March 13, 2023

RE: Responses to Comments  
Dutch Bros. Coffee (NM-0203)  
210 98th Street, N.W., Albuquerque, New Mexico 87121  
Erosion and Sediment Control Plan  
Our Job No. 22187

We have revised the plans and technical documents for the above-referenced project in accordance with your comment letter dated December 14, 2022. Enclosed are the following documents for your review and approval:

Title: **EROSION AND SEDIMENT CONTROL PLAN**
220 98TH STREET NW
ALBUQUERQUE, NM 87121

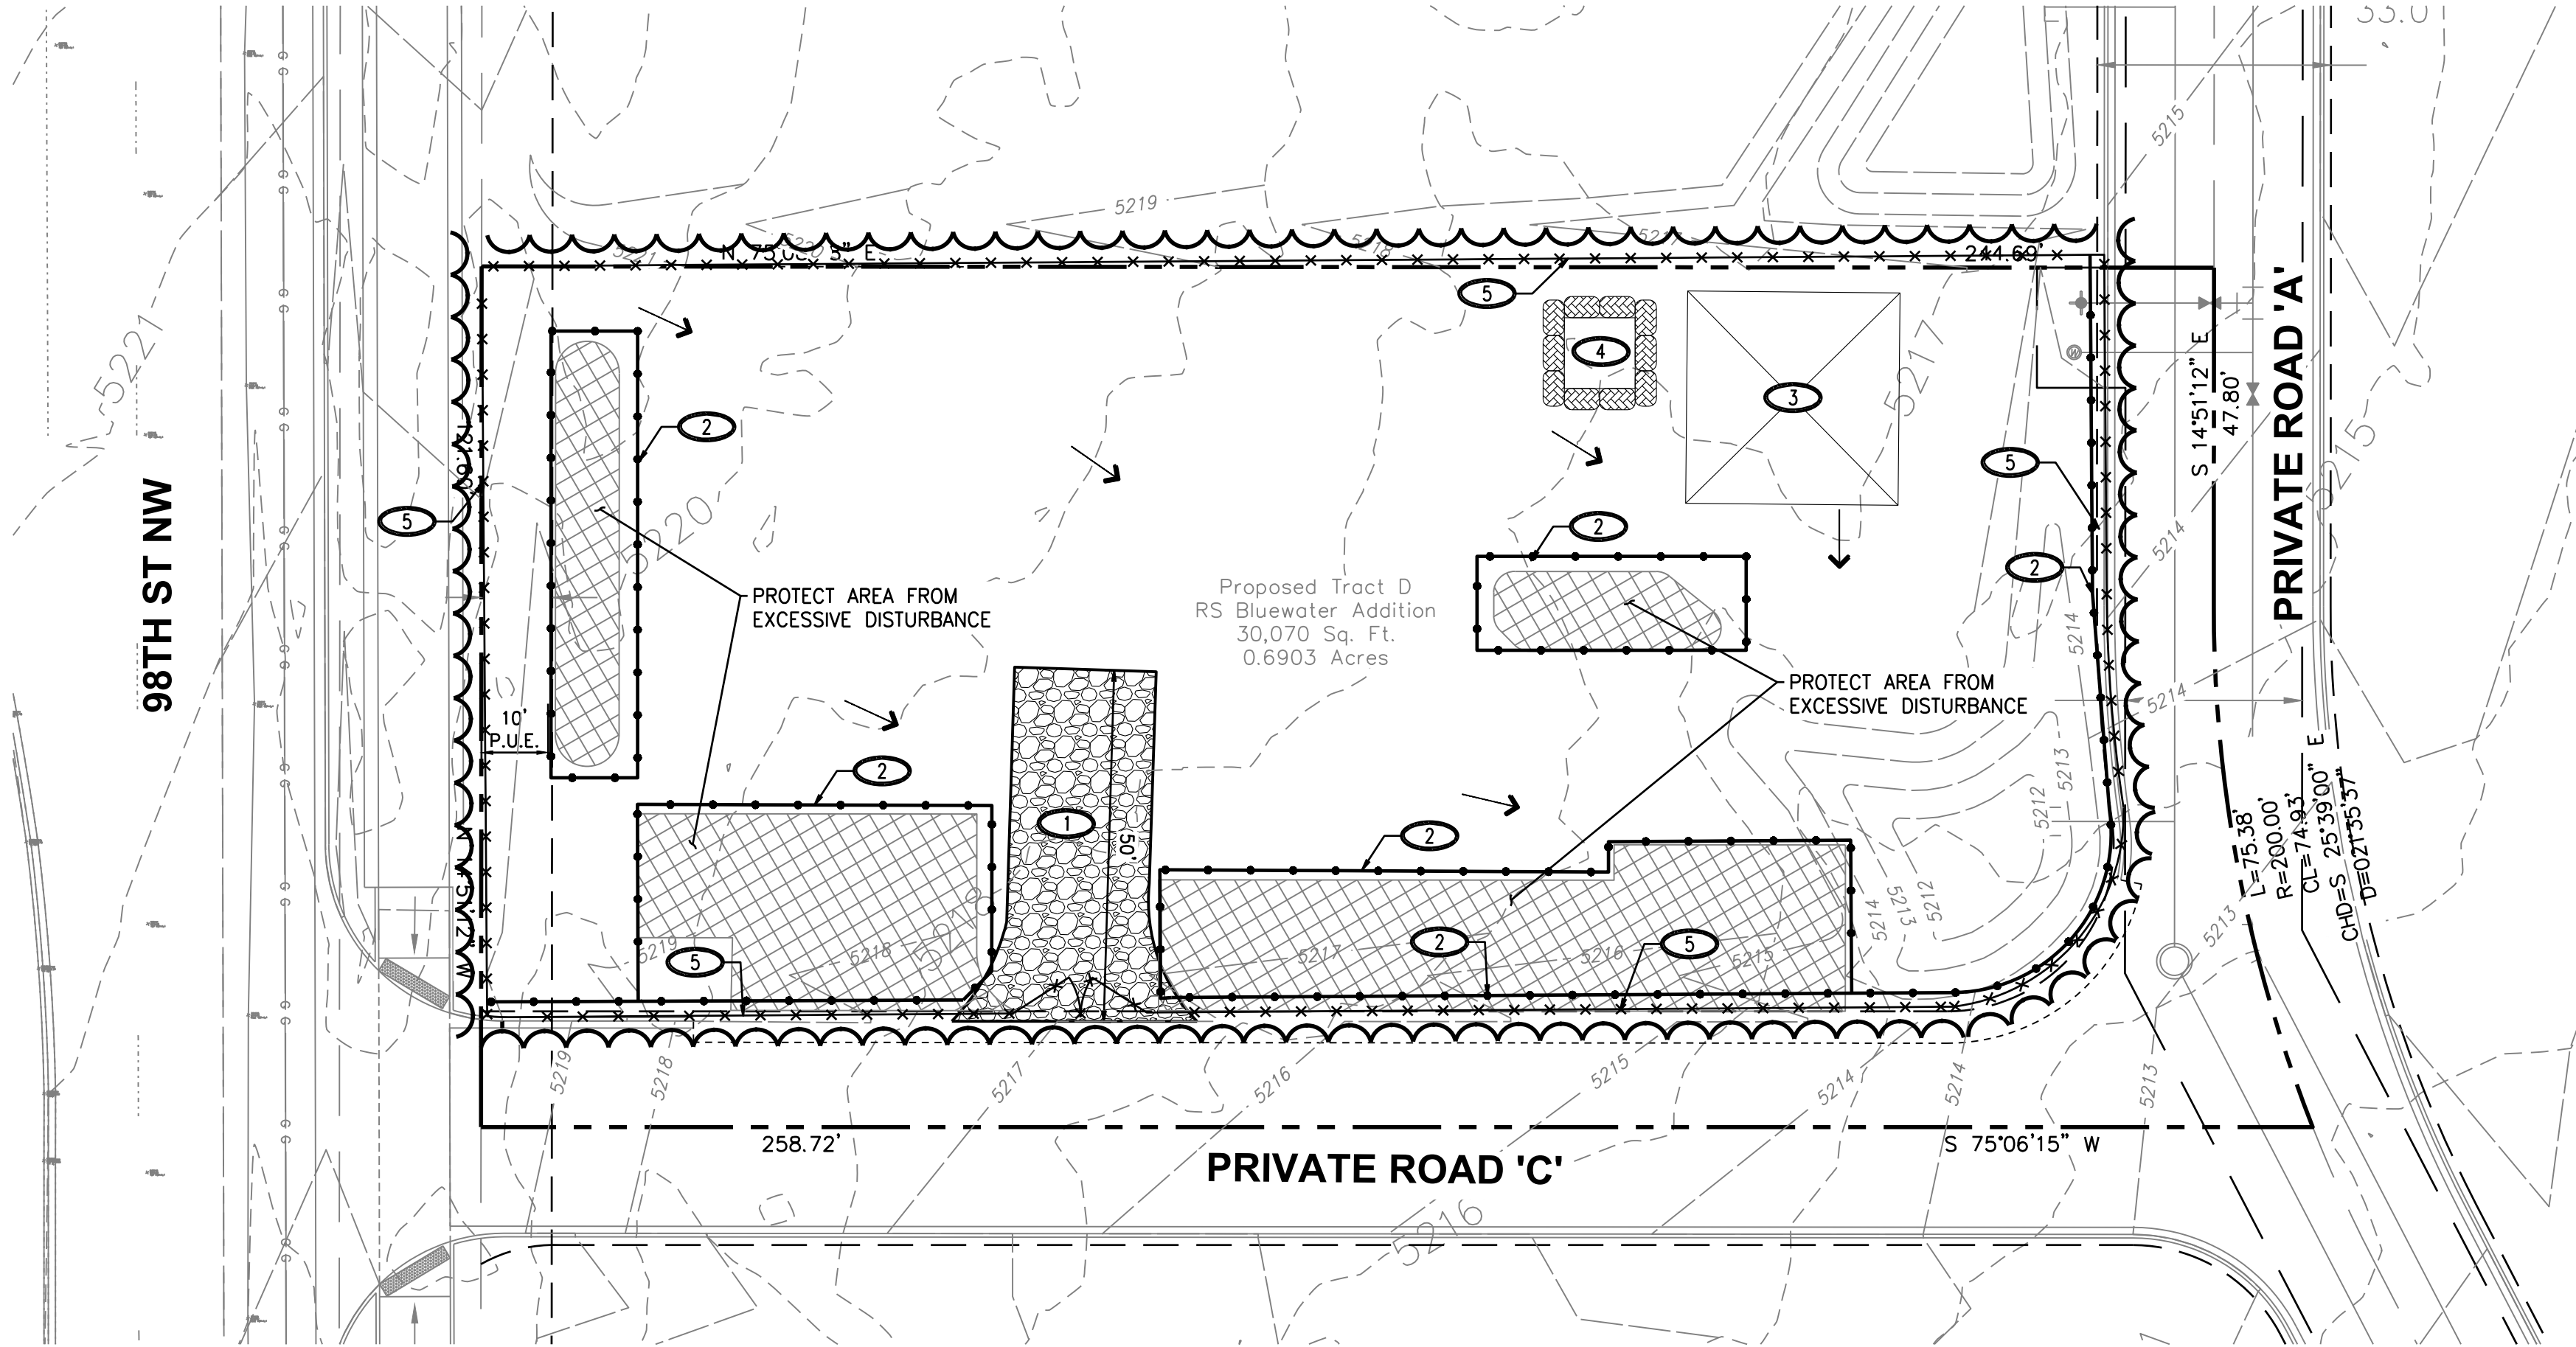
3. *Show all structures on the ESC Plan including the building, sidewalk, and asphalt.*

5. *Most of this site has already been disturbed so there isn't any benefit to "protecting areas from excessive disturbance" as shown on the ESC Plan. Silt fence is needed as a perimeter control along the streets. Revise based on current site conditions.*

6. *Describe the nature and extent of construction activities (CGP 7.2.2.). Include a description and project schedule per CGP 7.2.3.f through final stabilization, removal of BMPs, and filing NOT. Also note the size of the property and the total area of land disturbing activities.*

**Response:** Building, sidewalk, and asphalt are shown on ESC Plan.

**Response:** Removed note for "protecting areas from excessive disturbance" from plans.

**Response:** Project schedule added to Sheet C1.3. Refer to Section 2.3 in the SWPPP for the project description.
